Rezoning Transportation Analysis

Petition Number: 2021-079

From: Brandon Brezeale, PE

Date	Description
08-02-2021	First Review (WB)
08-23-2021	Second Review (WB)
09-17-2021	Third Review (KP)
10-18-2021	Fourth Review (PDM)
12-20-2021	Fifth Review (WB)

DRAWING NO.: **RZ-01**

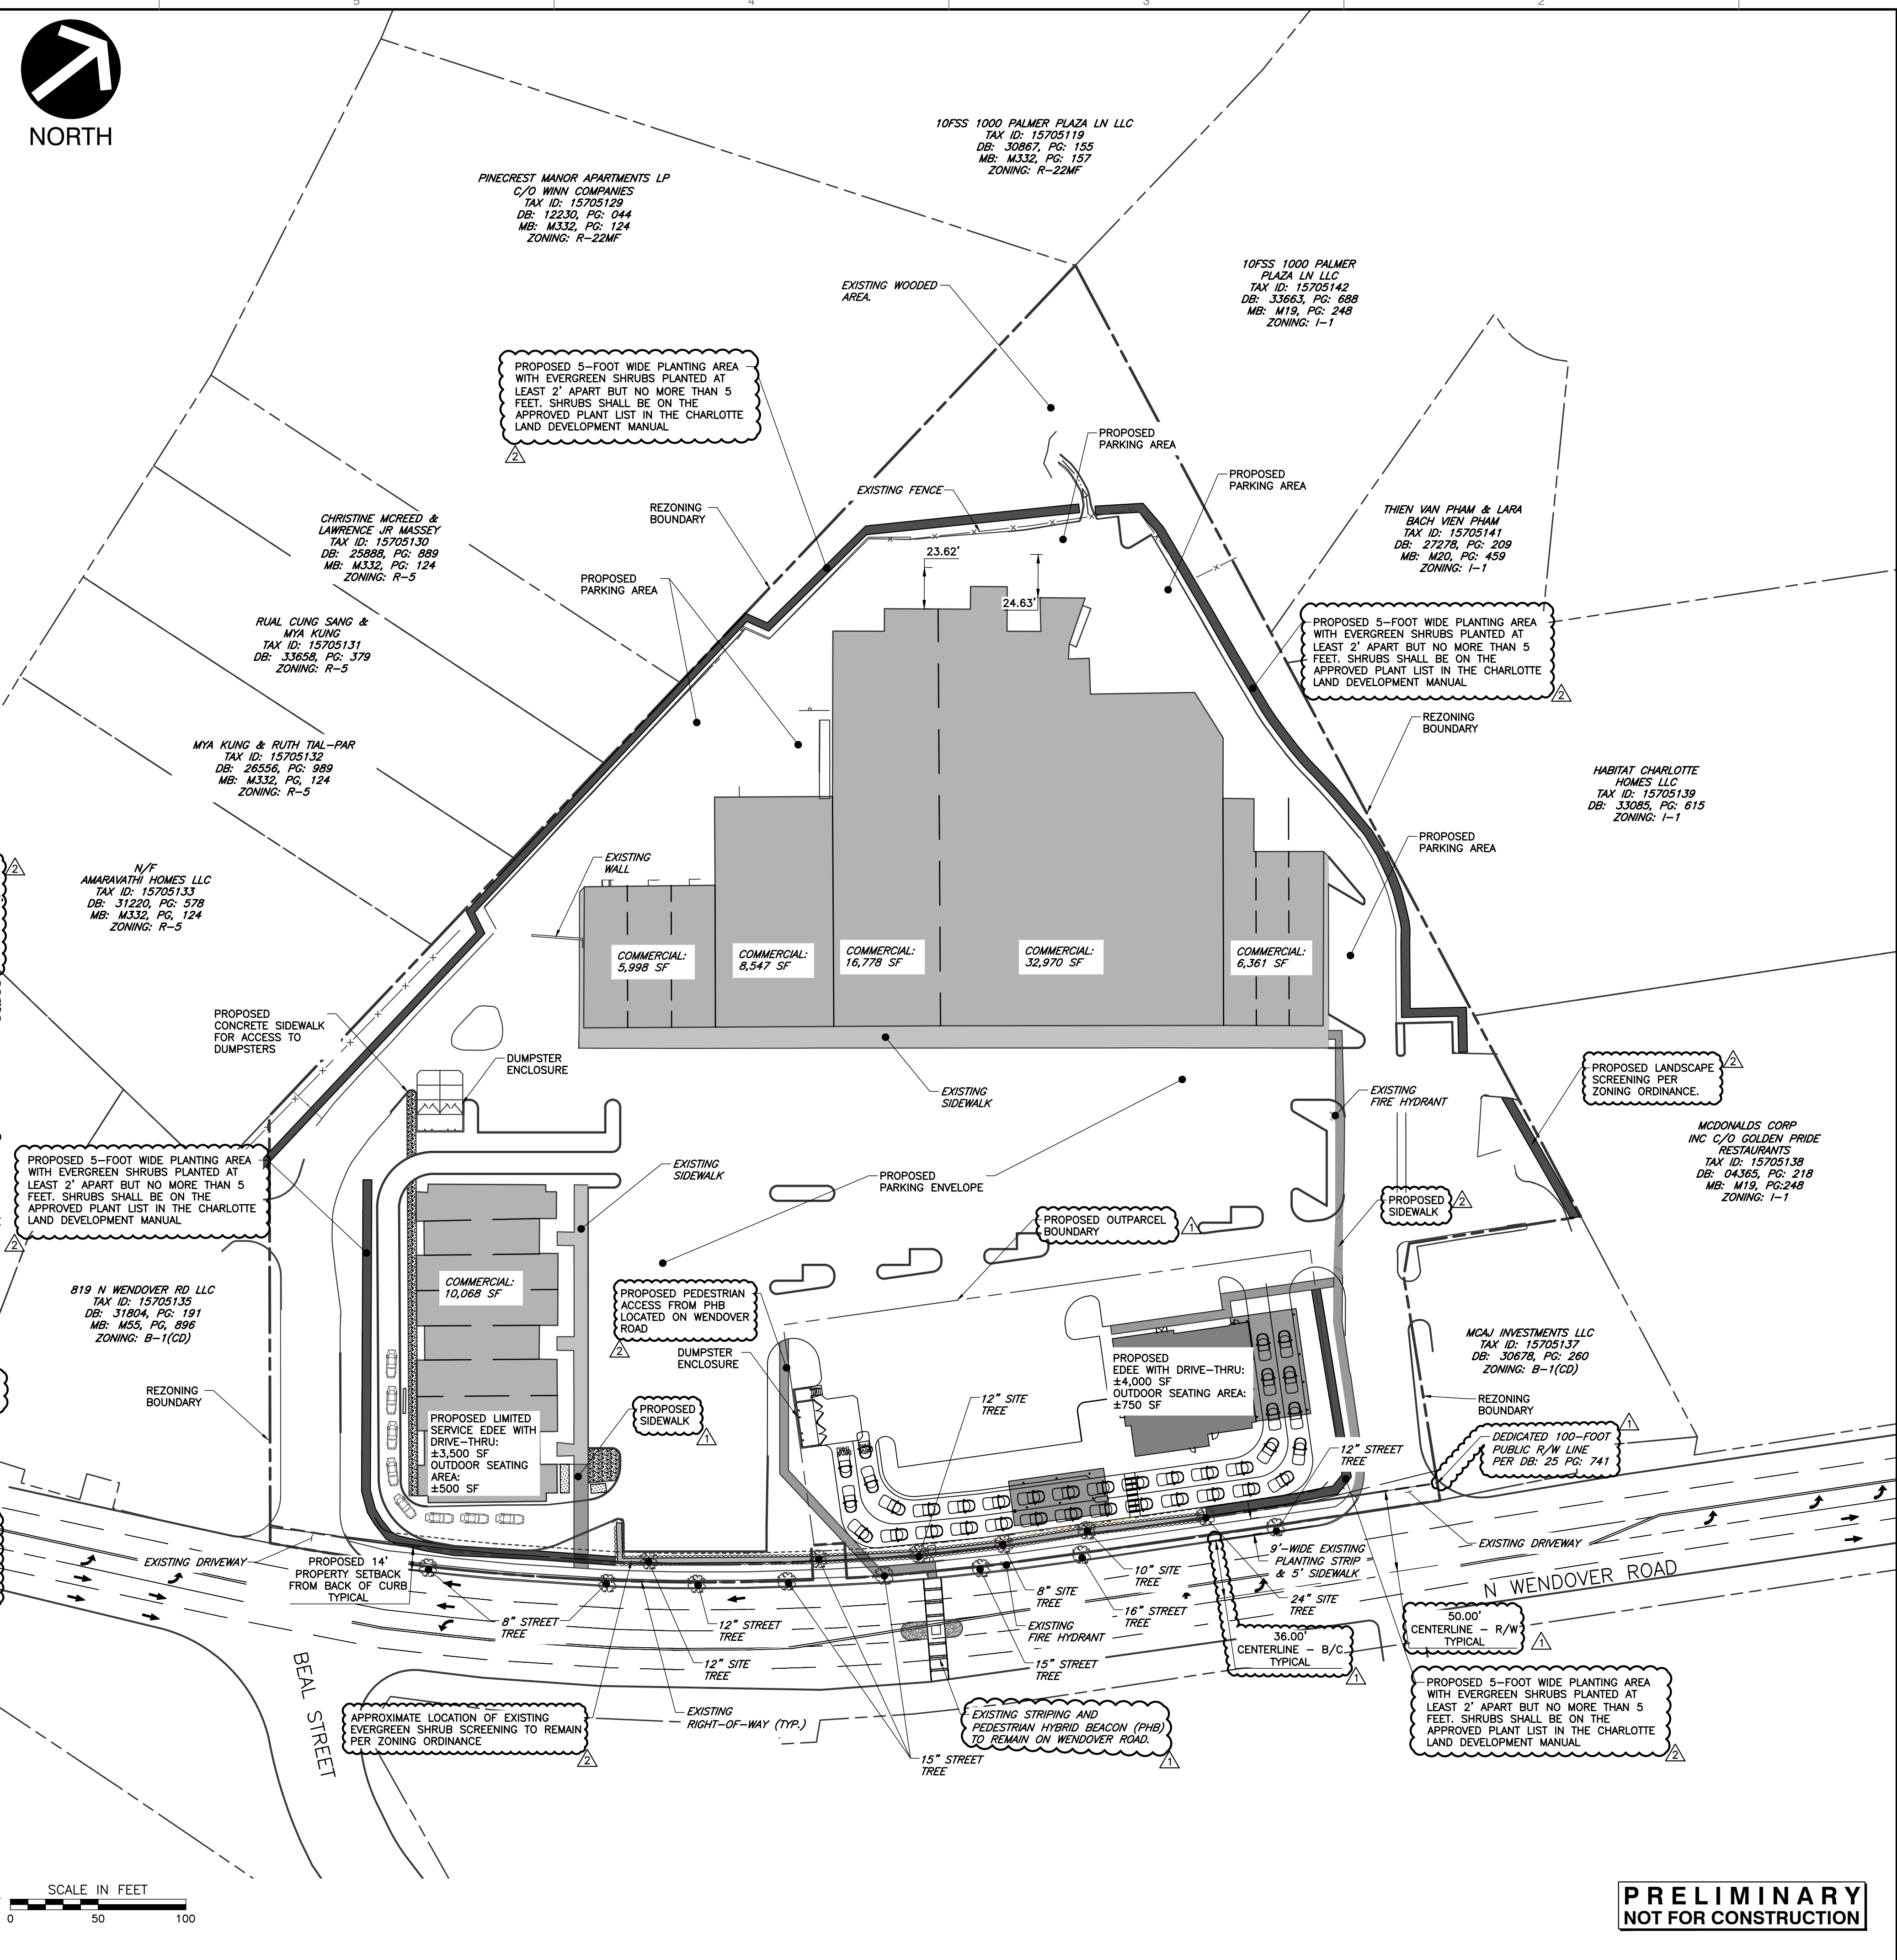
4. **Outstanding Comment from 08-02-2021:** Site plan and conditional note(s) revisions are needed to commit to installing a 12' multi-use path with an 8' planting strip along the site's frontage of Wendover Road to meet the Charlotte BIKES Policy.
